From: Sue Howell
Sent: 07 September 2016 12:26
To: Planning.Responses
Cc: David Innes
Subject: RE: Planning Consultation on: LU/201/16/RES

Comment from Greenspace

APPLICATION LU/201/16/RES

2016
Site Address: Windroos Nursery Worthing Road Littlehampton BN17 6LY
Grid Reference: 503578 103376
Description of Works: Approval of reserved matters following outline consent
LU/229/10/ for appearance, landscaping, layout & scale for 85
No. dwellings

CLIENT	STUART & MARCIA LYONS		
PROJECT	WINDROOS, LITTLEHAMPTON		
TITLE	PLANTING PLAN 2 of 2		
NUMBER	13121 - P.10.007 P1		
DATE	SCALE	STATUS	DRAWN / CHECKED
July 2016	1:250 @ A1	PLANNING	AH/DR

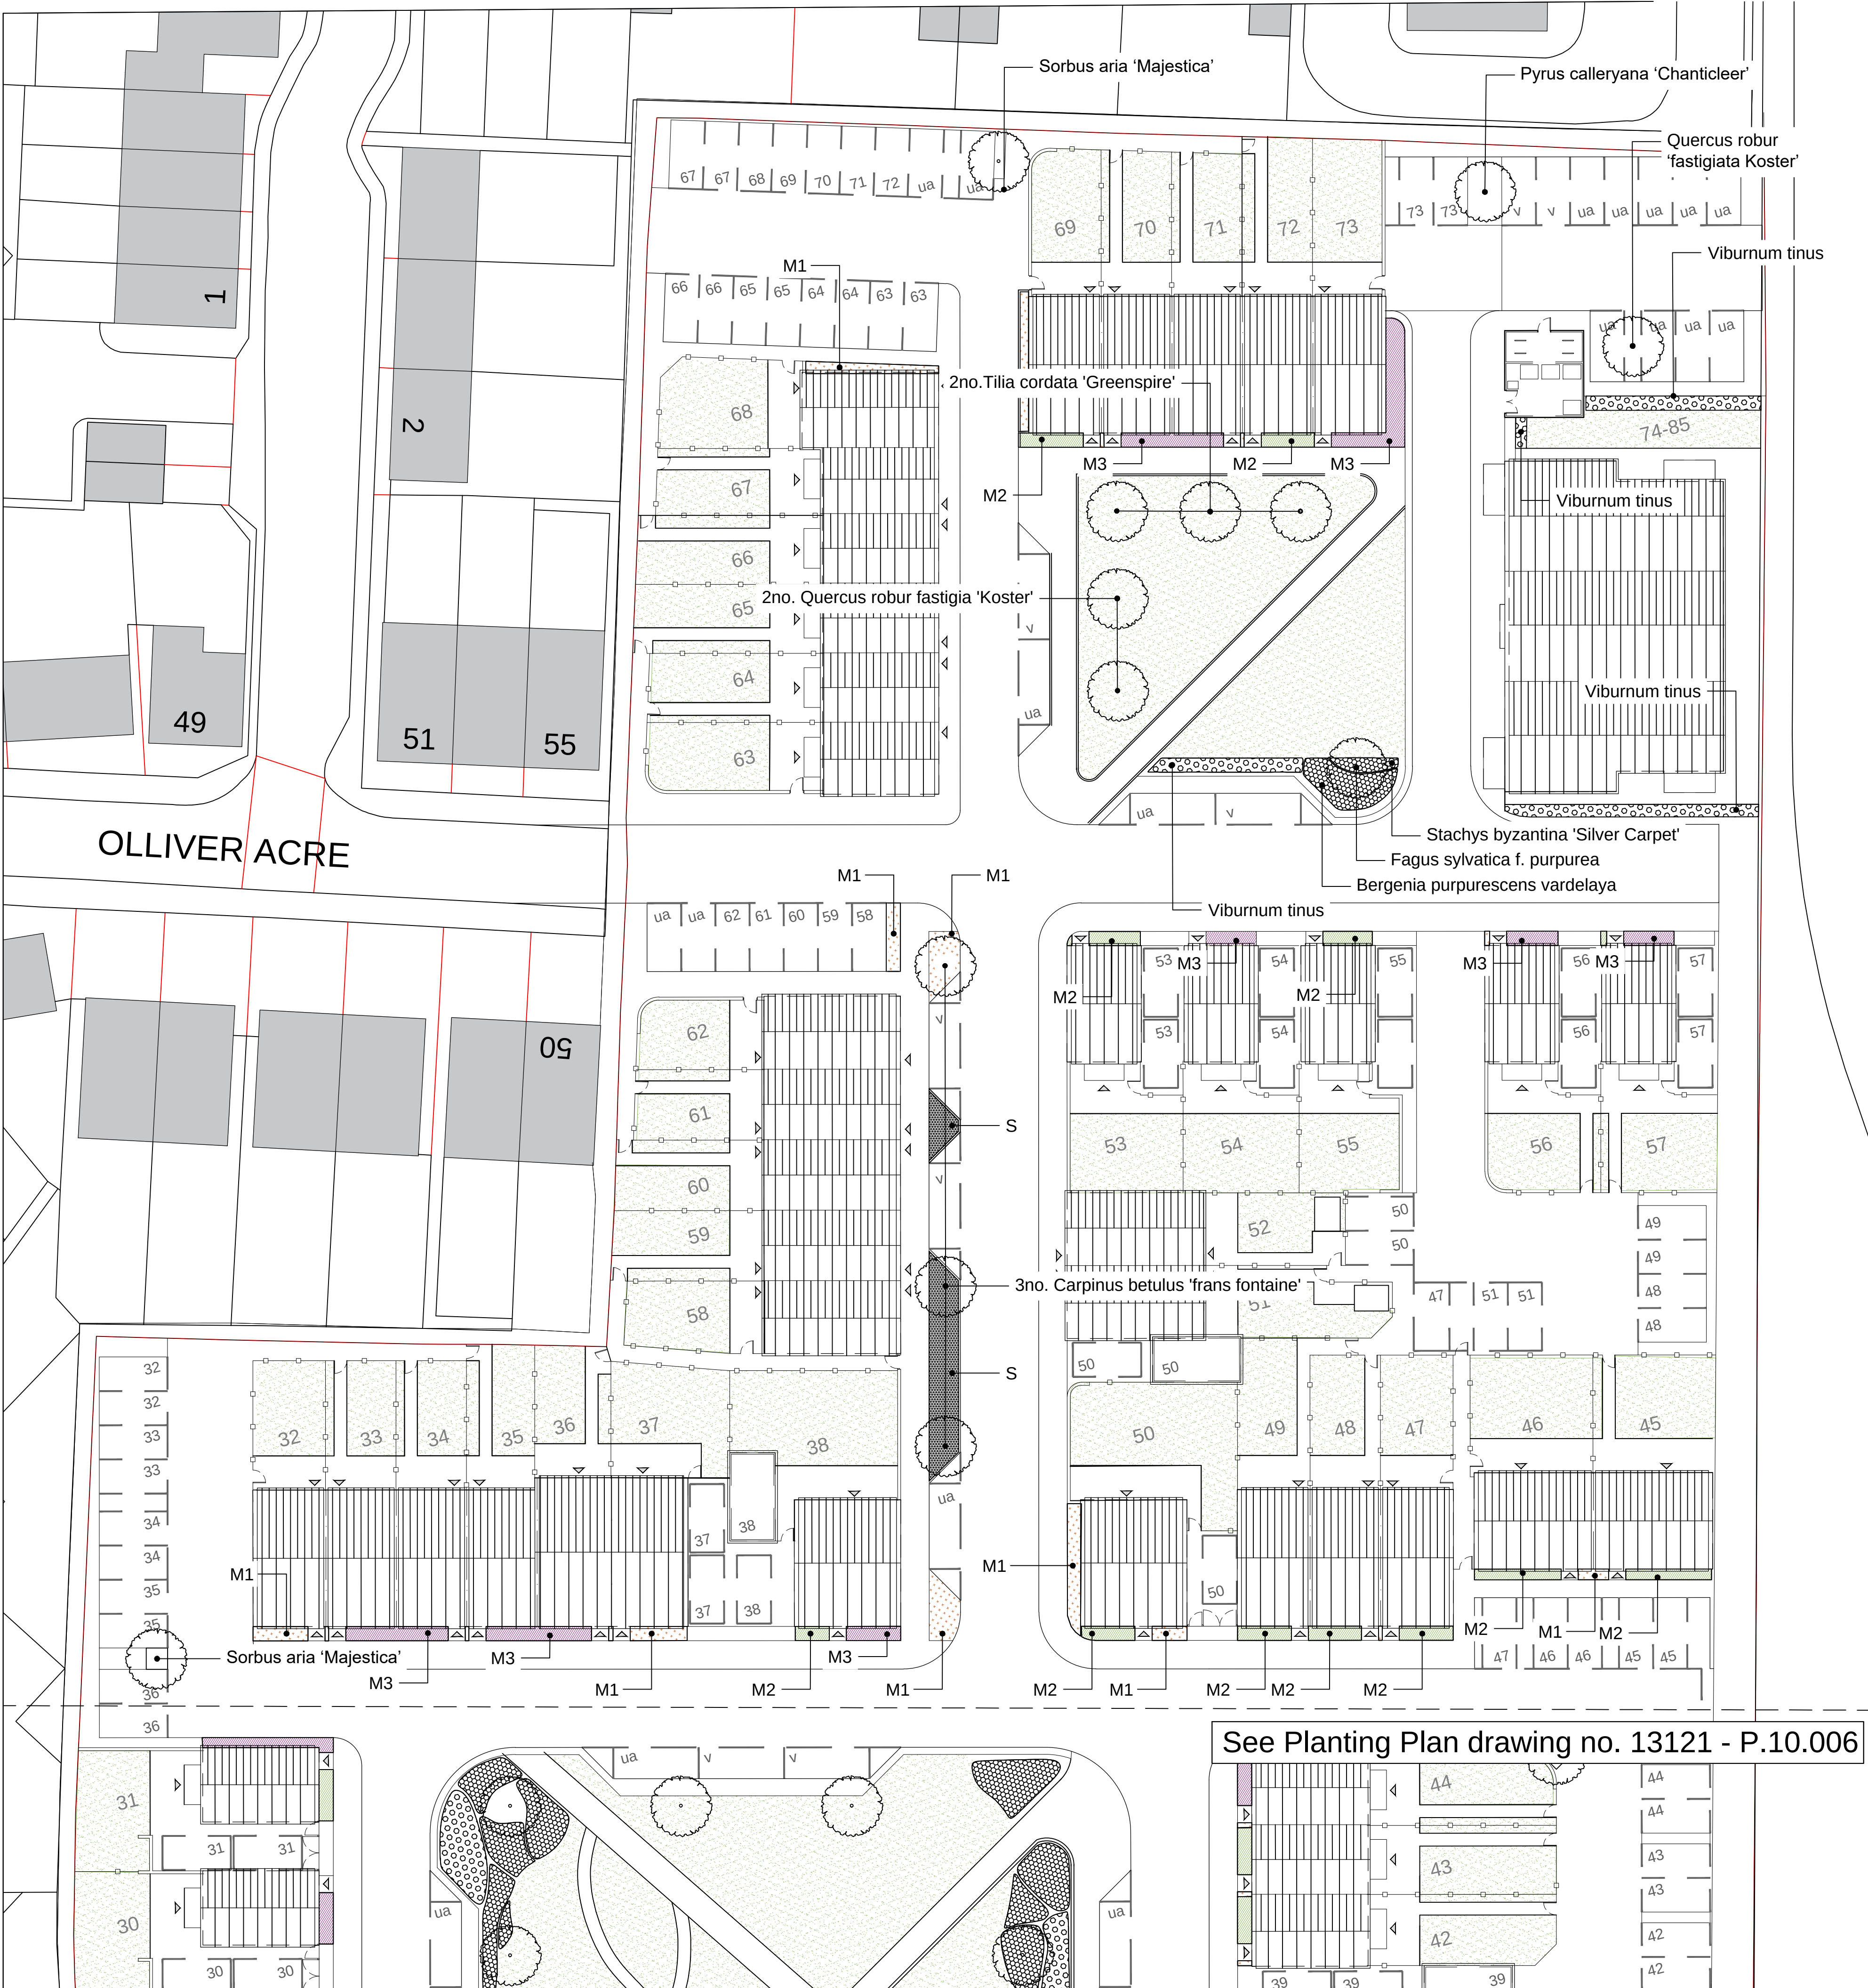
This application has included a detailed and well thought out scheme of trees and shrubs that are both suitable and fitting for location. The schedules and detail contained within dwg 13121-P.10.006 P1 & dwg 13121-P.10.007 P1 **do not however** contain specific quantities, which would be a requirement in plan form.

Our recommendation therefore would be that these drawings are amended to show actual quantities in location rather than just detail of the variety for location or just percentage mix.
